PLANNING AMENDMENT

APPLICANT NAME AND ADDRESS MR D & A RULEWSKI GLASTONBURY HOUSE 45A LOW LANE HOLBEACH SPALDING PE12 7PW Telephone: [REDACTED]	AGENT NAME AND ADDRESS AS PER APPLICANT DETAILS Telephone:
SITE ADDRESS DETAILS 47 LOW LANE HOLBEACH SPALDING PE12 7PW	
CURRENT APPLICATION NO: This amendment cannot be considered unless the relevant reference is stated.	H09-0801-20
Building Regulation reference relating to same development (if applicable)

FULL DESCRIPTION OF DEVELOPMENT OF CURRENT APPLICATION THAT THIS AMENDMENT RELATES TO	ERECTION OF FIVE DETACHED TWO STOREY DWELLINGS, ONE DETACHED DOUBLE GARAGE AND DEMOLITION OF EXISTING BUNGALOW
State details of amendments proposed. (Give a full detailed list of the changes, and also mark these clearly on the accompanying plans. Only the changes listed here will be considered)	REDUCTION FROM 5 DWELLINGS TO 4 DWELLINGS. PLOTS 2 & 3 OMITTED AND REPLACED WITH A SINGLE DETACHED TWO STOREY DWELLING AND DETACHED DOUBLE GARAGE. RENUMBERING OF PLOTS 2-5 TO 2-4 REPOSITIONING OF RENUMBERED PLOTS 1-4 IN RELATION TO BOUNDARIES, EXISTING PROPERTIES AND ACCESS ROAD.

Sheet Size: A3	Project No: -
Drawing No: 008	Revision: Rev B
Date: November 2020	Drawn: DR
Scale: 1:100	Checked: RR Approved: DR

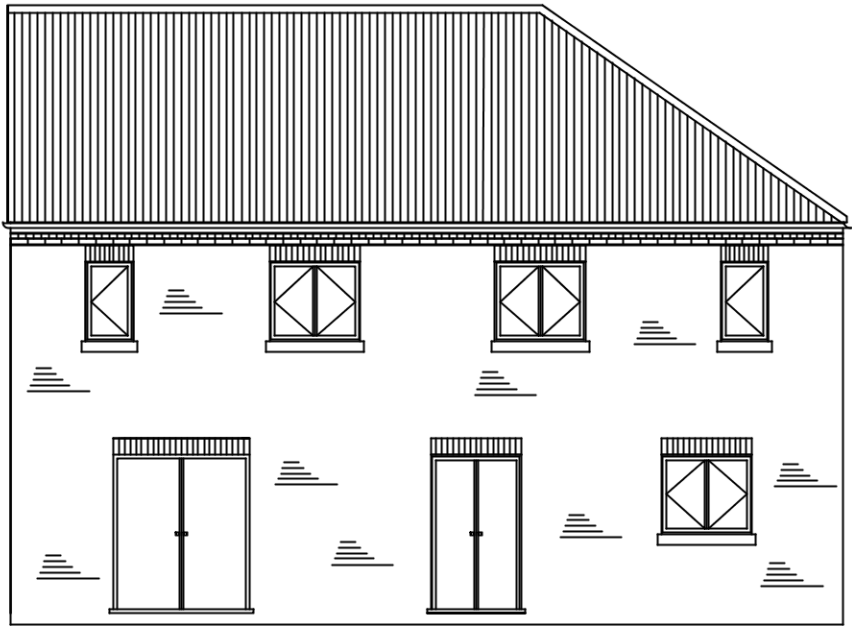
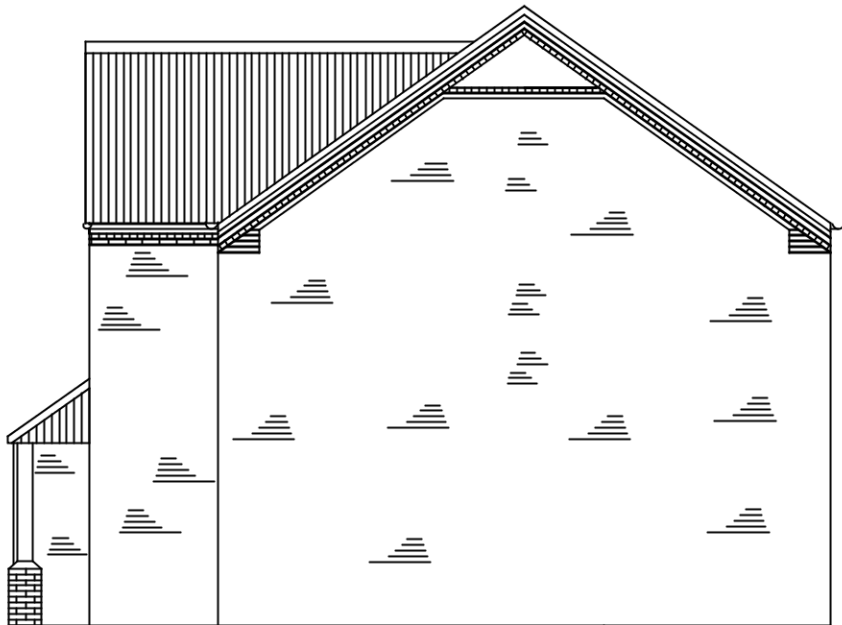
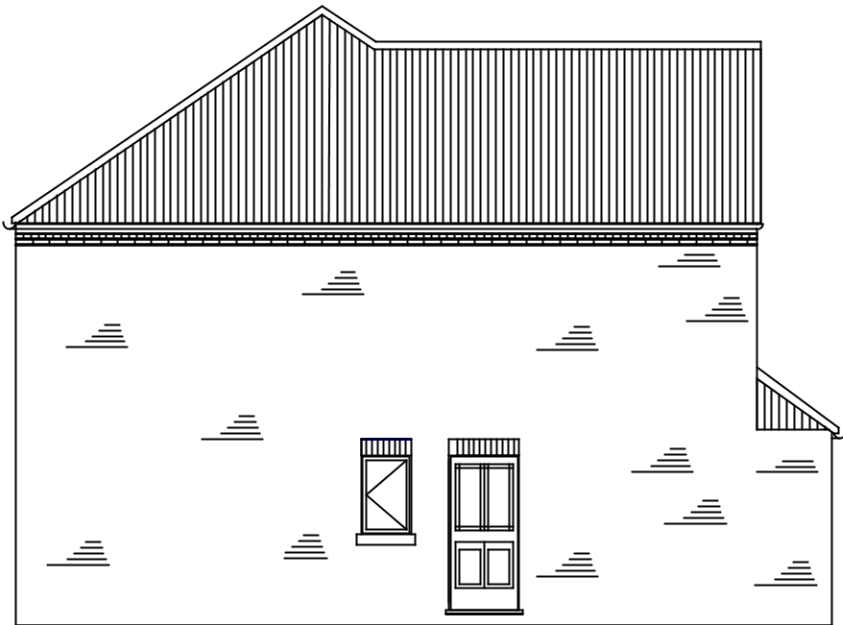
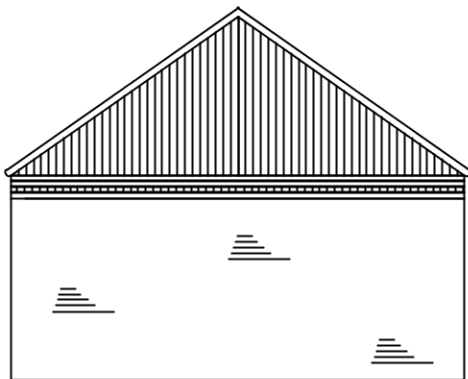
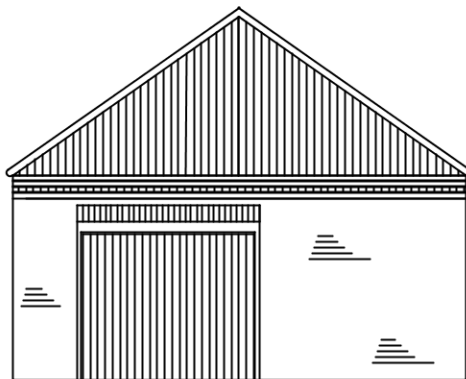
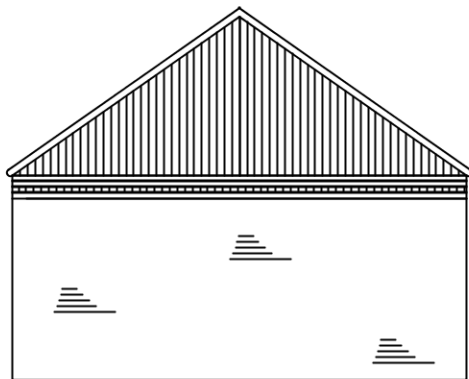
REVISED PLOT NUMBER 4 GARAGE REDUCED FROM DOUBLE GARAGE TO SINGLE GARAGE WITH INTEGRAL GARDEN STORE AND REPOSITIONED TO REAR OF PLOT 4 AND AMENDED DRIVE ACCESS AND POSITION. AMENDMENT TO ACCESS ROAD LAYOUT AND REVISION OF FIRE FIGHTING APPLIANCES TURNING CIRCLE TO SATISFY FIRE OFFICERS OBJECTIONS. AMENDMENTS TO NOTES TO INCLUDE CONFIRMATION OF ACCESS ROAD SPECIFICATION TO SATISFY FIRE OFFICERS AND LINCOLNSHIRE COUNTY COUNCIL COMMENTS. AMENDMENTS TO NOTES TO INCLUDE PROVISIONS OF SWIFT BRICKS, NATIVE WILDFLOWER PLANTING & APETURES WITHIN BOUNDARY TREATMENTS FOR WILDLIFE. INDICATIVE BOUNDARY TREATMENTS, FOOTPATHS AND PARKING PROVISIONS TO PROPERTIES. REVISED TITLE BLOCKS.	
State drawing numbers of the current submission	001 – SITE & LOCATION PLANS REV A 002 – PLOT 1 - ELEVATIONS - REV A 003 – PLOT 1 – FLOOR PLANS – REV A 004 – PLOT 2 – ELEVATIONS – REV A 005 – PLOT 2 – FLOOR PLANS – REV A 006 – PLOT 3 – ELEVATIONS – REV A 007 – PLOT 3 – FLOOR PLANS – REV A 008 – PLOT 4 – ELEVATIONS – REV A 009 – PLOT 4 – FLOOR PLANS – REV A 010 – PLOT 5 – ELEVATION – REV A 011 – PLOT 5 – FLOOR PLANS – REV A
